Development Facilitation Team (DFT) – Review Comments

Project No: PR-2021-005151 Date: 08/23/2023 Agenda Item: #10 & 11 Zone Atlas Page: A-12

Application For: SD-2023-00124-PRELIMINARY PLAT (DHO)

Project Name: Paradise Heights, Unit 1

ENGINEER'S SEAL	GOLF COURSE + WESTSIDE ALBUQUERQUE, NM	DRAWN BY RG
	<b>SIDEWALK AND PAVING EXHIBIT</b>	DATE 03/14/2023
		2022055_PAVING
Vincent P. Carrica # 16212	5571 MIDWAY PARK PLACE NE ALBUQUERQUE, NM 87109 (505) 858-3100 www.tierrawestllc.com	SHEET # C1
		JOB # 2022055

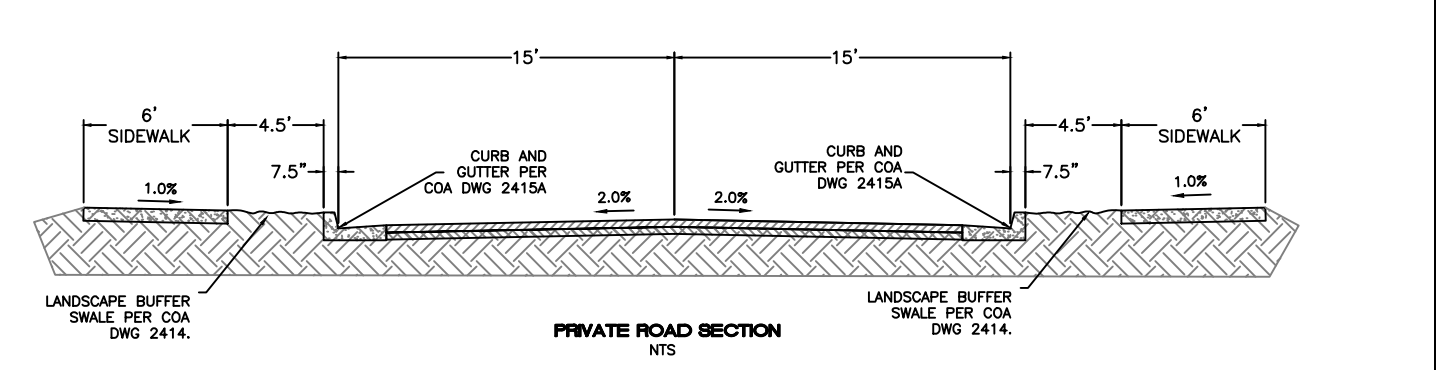
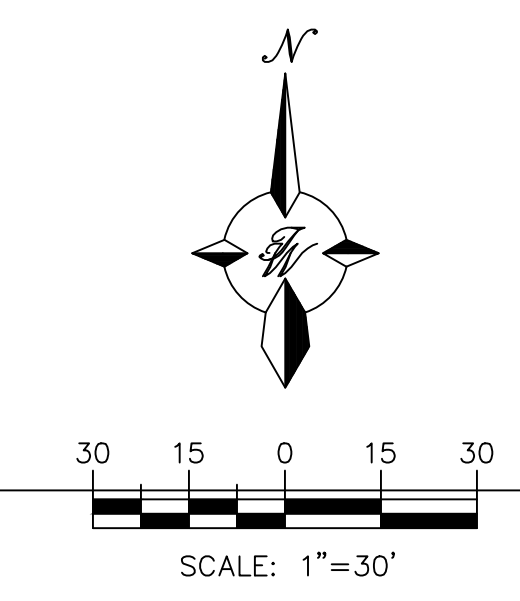
- **Update 8/21/23: The applicant provided sheet C1 (Sidewalk and Paving Exhibit) confirming that all sidewalks are at least 6 feet in width. Existing sidewalks will remain and new sidewalks will be pushed back from the curb as possible.**
~~Please confirm the compliance with section 7 of the DPM Table 7.2.29 regarding Sidewalk width requirements and its landscape buffer.~~
~~-Standards and Requirements per Transportation-~~
 Property not within a Center or Corridor area.
